**KIRKLEES METROPOLITAN COUNCIL  
INVESTMENT & REGENERATION SERVICE**

**DELEGATED DECISION TO DETERMINE PLANNING APPLICATIONS**

Reference No:	<b>2023/62/90891/W</b>
Site Address:	1, West Avenue, Lindley, Huddersfield, HD3 3LR
Description:	Erection of detached garage and detached garden room, demolition and re-position gate posts (within a Conservation Area)
Recommending Officer:	Lucy Taylor

## **Officer Report.**

Proposed revised gate post positions

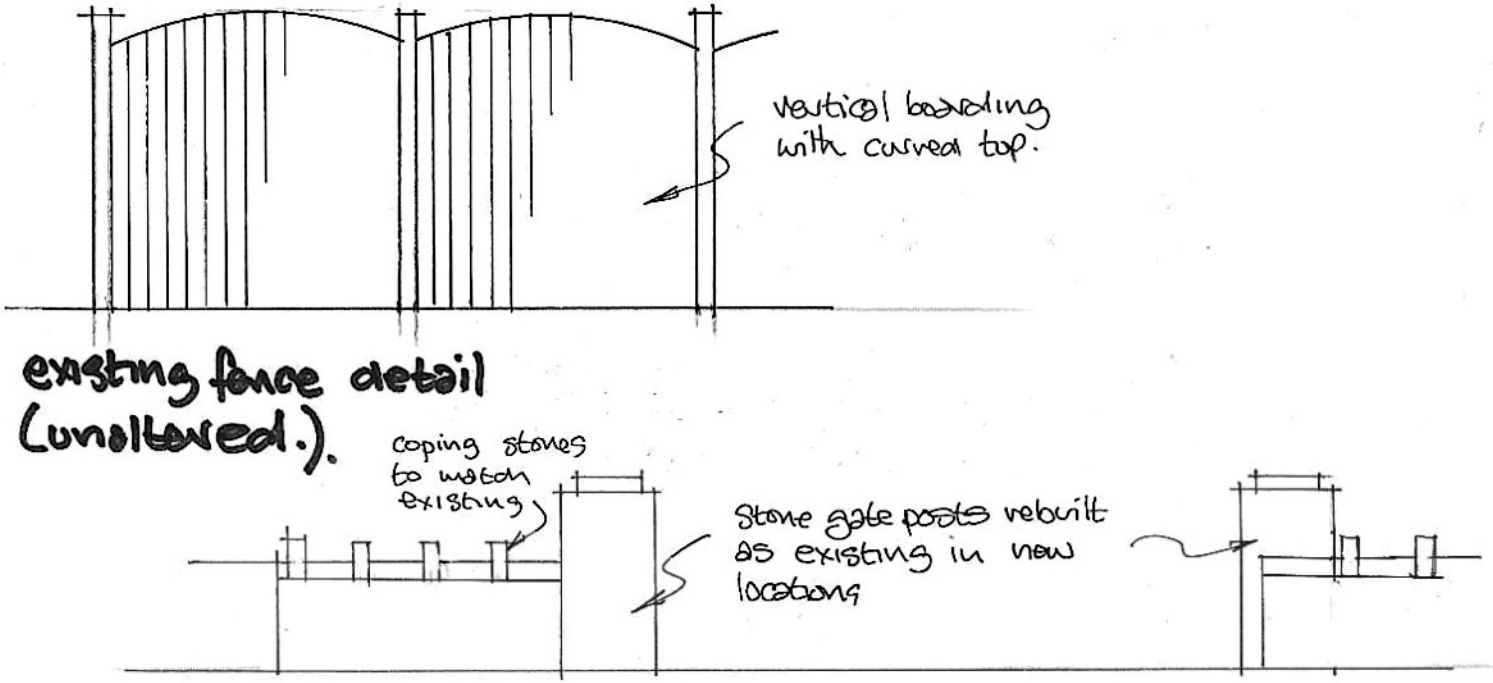
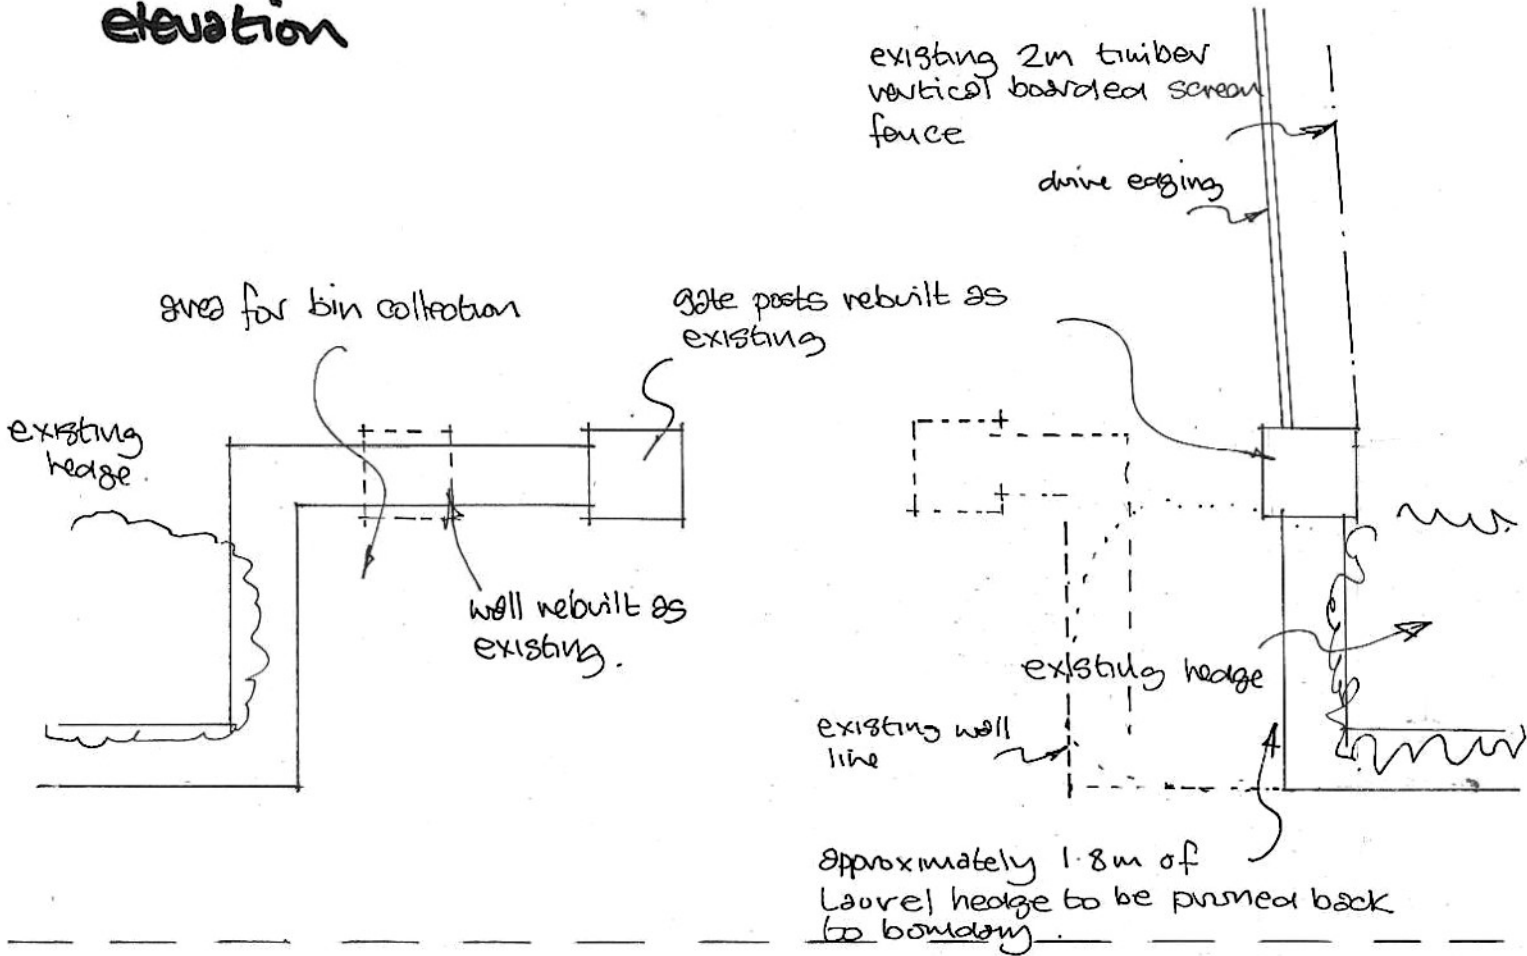
The works to the gate posts and driveway are concluded to be visually acceptable, with the original gate posts and walls to be retained and relocated. Therefore, these works are considered to retain the original/existing character of the site within the context of the host property and wider streetscene.

The alterations to the gate posts would not significantly alter existing routes of vehicle access to and from the site with regard to the highway and, upon any grant of approval, a condition would be included to ensure that the widened driveway be surfaced permeably for reasons of drainage.

Proposed detached single garage at 1 West Avenue Lindley HD33LR

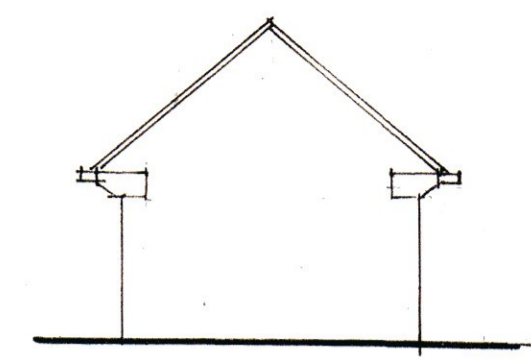
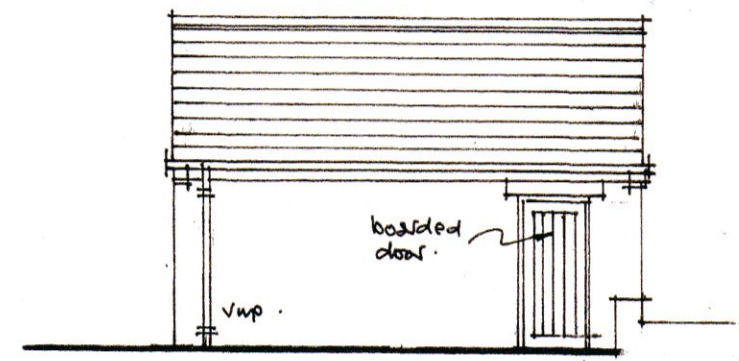
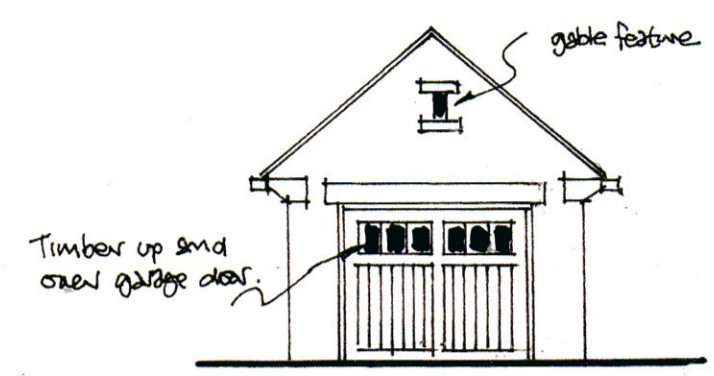
Following an informal consultation with KC Conservation and Design, the case officer sought amendments to the originally proposed detached garage, recommending that it be re-located within the site, reduced in size/scale and faced in stone to match the dwellinghouse.

Following the submission of amended plans, the proposed detached garage is considered to be visually acceptable. The garage would be of an acceptable single storey size/scale and would be sited behind the front build line of the host property within the site. In addition, the garage would be faced in stone to match the appearance of the host dwelling.

In response to these recommendations, the applicant submitted amended plans in accordance with the case officer's design recommendations.
